Appeal Decision

Appeal Ref: APP/R5510/D/18/3212962

9b Angus Drive, Ruislip HA4 0RZ

EXISTING FLOOR PLANS

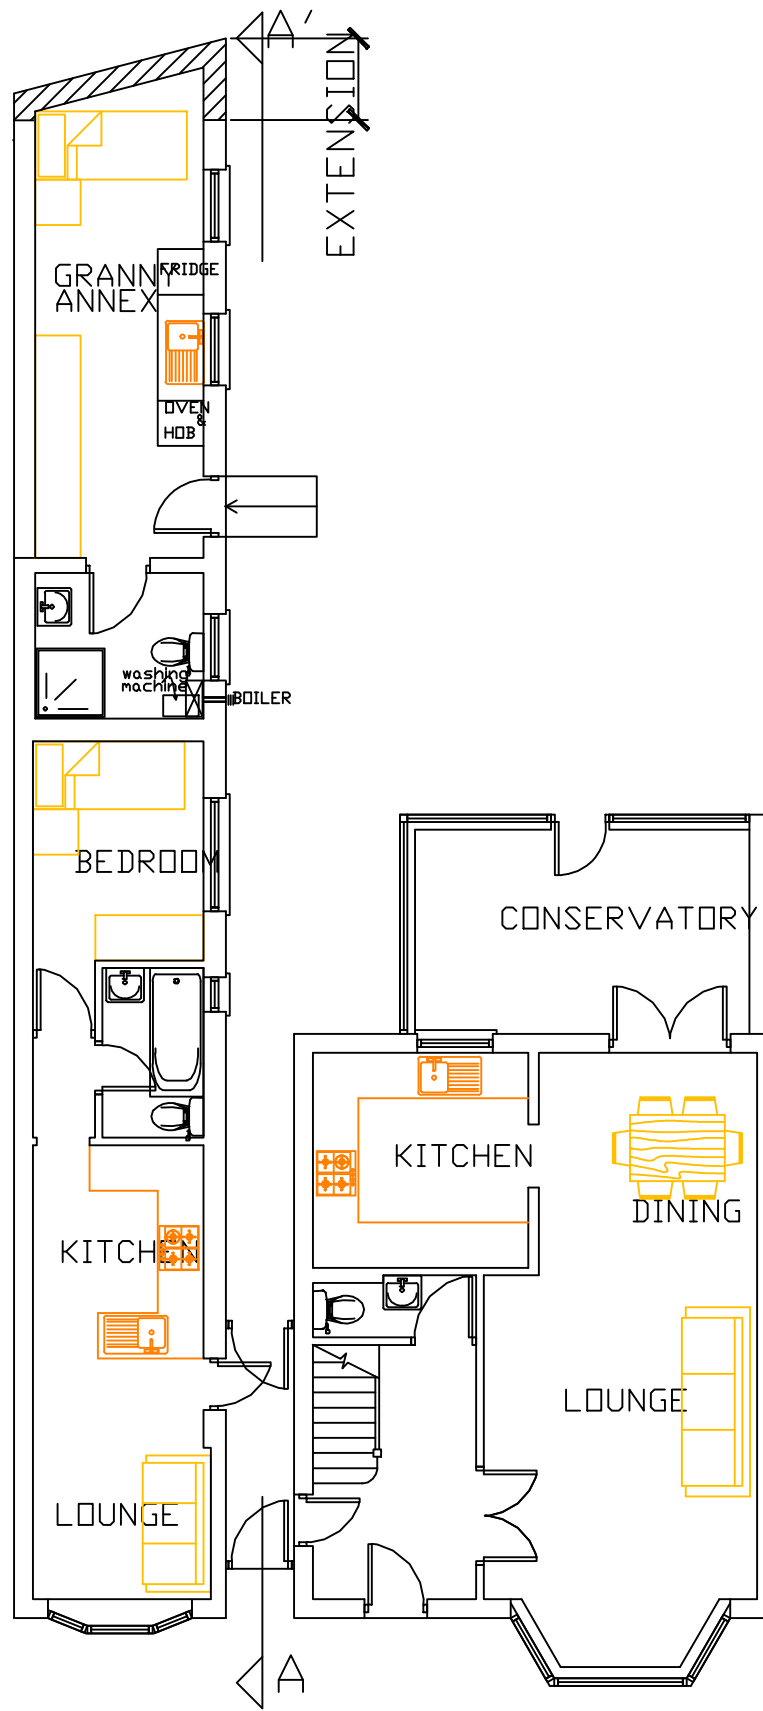
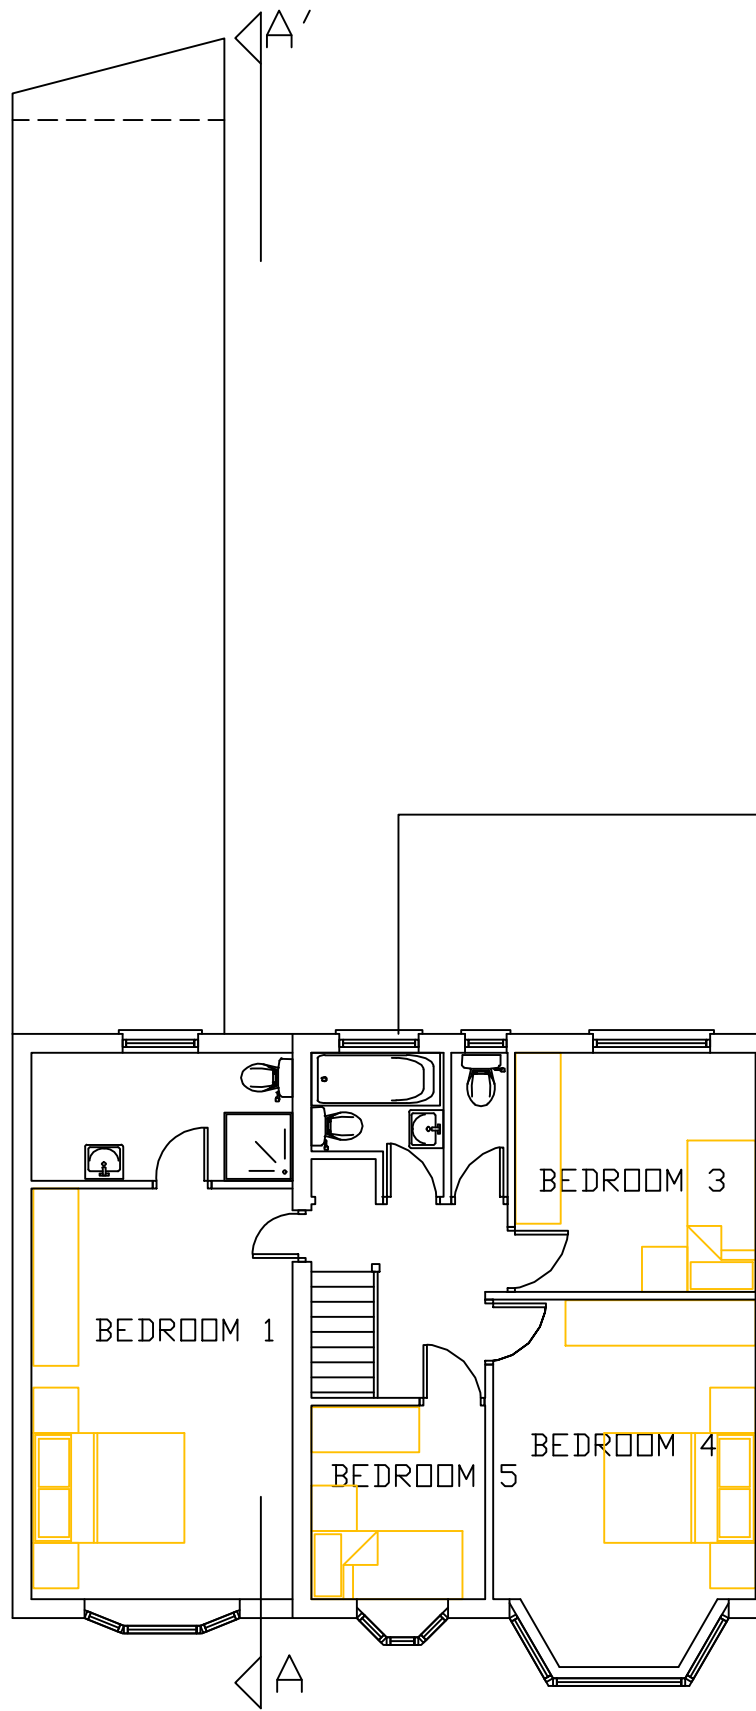
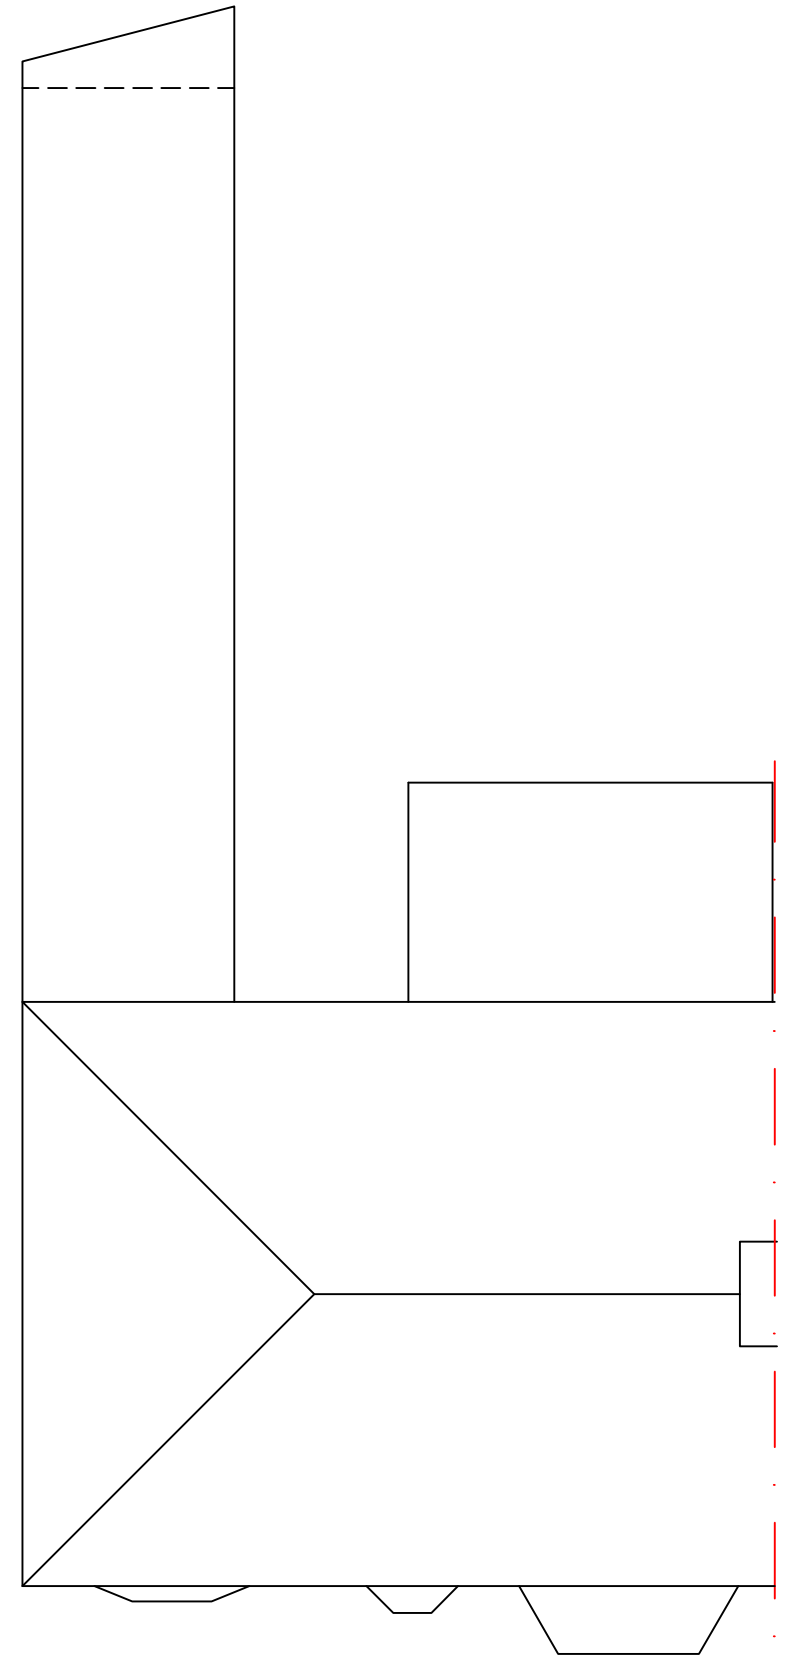
4. On the first issue, the Council's Notice of Refusal refers to the extension being of excessive depth resulting in '*an over dominant and visually obtrusive form of development which is out of keeping with the local area and does not represent a subordinate addition*'. However, the element of operational development constituting enlargement in the appeal scheme is modest, comprising an increase in height of an existing workshop from a height of 2.49m with a flat roof to 2.75m, also with a flat roof, and an extension in length of 1m tapering to 0.2m and to its new height.

5. The Council is correct to observe that the extension as now completed and occupied and including the previously permitted extension to the flat at 9a runs the full length of the rear garden along the boundary with No. 48 The Fairway and as such is in breach of the Council's adopted Supplementary Planning Document HDAS: 'Residential Extensions' (HDAS) 2008.

6. However, from the public realm there are, at most, only glimpses of the roof of the extension above the boundary fence. And given the extension's modest height, narrow width and linear form along the boundary I consider it very unlikely that there would be any harmful impact in the outlook from the surrounding properties. The absence of any neighbour objections would appear to support this assessment.

7. Taking these points into account and noting in comparison the height and bulk of the extension to the other half of the semi-detached pair No. 7 (albeit with only a limited depth) I consider that, the technical breach of HDAS notwithstanding, the extension is neither over dominant nor visually obtrusive. The unusual length might be considered to be somewhat out of keeping, but I do not accept this is harmful to the character of the area, and this is particularly relevant to the very modest extensions made to the pre-existing workshop.

1. The appeal is allowed and planning permission is granted for the erection of a single storey addition to the existing extension and increasing the roof to the same height as existing and use as self-contained accommodation for occupation ancillary to 9b Angus Drive, Ruislip in accordance with the terms of the application, Ref. 73758/APP/2018/1493, dated 24 April 2018 and as amended by this Decision subject to the following conditions:

- 1) The development shall be carried out in accordance with the following approved plans: Drawing Nos. 06/2685 (OS based Location Plan); 17/3159/2 Rev. B (Pre-Existing Site Plan); 17/3159/2 (Existing Site Plan); 17/3159/3 Rev. B (Pre-Existing Floor Plans); 17/3159/5 (Existing Floor Plans); 17/3159/4 Rev. C (Pre-Existing Elevations); 17/3159/6 Rev. A (Existing Elevations);

- 2) The extension hereby permitted shall not be occupied at any time other than for purposes ancillary to the residential use of the dwelling known as No. 9 Angus Drive, Ruislip.
